<b>Application Ref:</b>	3/2025/0289			 <p>Ribble Valley Borough Council <a href="http://www.ribblevalley.gov.uk">www.ribblevalley.gov.uk</a></p>
<b>Date Inspected:</b>	11/06/2025	<b>Site Notice:</b>	11/06/2025	
<b>Officer:</b>	MC			
<b>DELEGATED ITEM FILE REPORT:</b>				<b>APPROVAL</b>

<b>Development Description:</b>	Outline application for the proposed erection of a farm workers dwelling with access applied for (all other matters reserved).
<b>Site Address/Location:</b>	Thornley Hall Farm Up Bedlam Road Thornley PR3 2TN

Title: Proposed Site Plan	
Drawing No: Air/1164/3545/04	Drawn: MP
Client: G.E. Airey & Sons	
Date: 17.07.2025	Scale: 1:250 @ A2
Amendments:

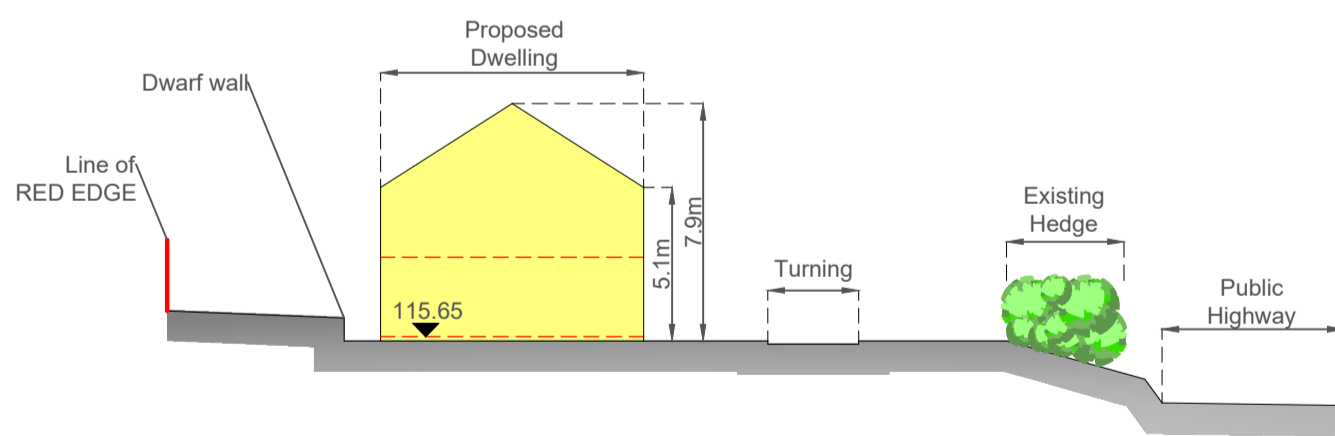
The Council had concerns regarding the gradient of the site, which raises up from the roadside. As such, the agent for the application submitted a section drawing to identify an illustrative siting of the proposed dwelling.

Following ongoing discussions between the agent for the application and the Planning Officer, the indicative siting of the dwellinghouse has been amended so that the dwelling now runs parallel to the northwestern boundary and the single storey garage would be sited on the northern side of the dwelling, closest to the road. In addition, the curtilage has been slightly reduced to the south and southeast to reduce encroachment into the open countryside and the plans confirm the extent of roadside trees and hedgerow that can be retained to provide some mitigation.

The LHA has reviewed the proposed site plan and note that the access is to be 4.5m wide. However, the visibility splay does not appear to have been drawn correctly on the plan, particularly on the west side.

Notwithstanding this, the LHA have undertaken their own assessment which has found that the visibility splay can be achieved within the red and blue edges of the development and as such, the visibility splay requirements can be secured by way of planning condition. They also consider that the access is required to be surfaced in hard-standing material for at least the first 5m into the site and should have a gradient no steeper than 1:10.
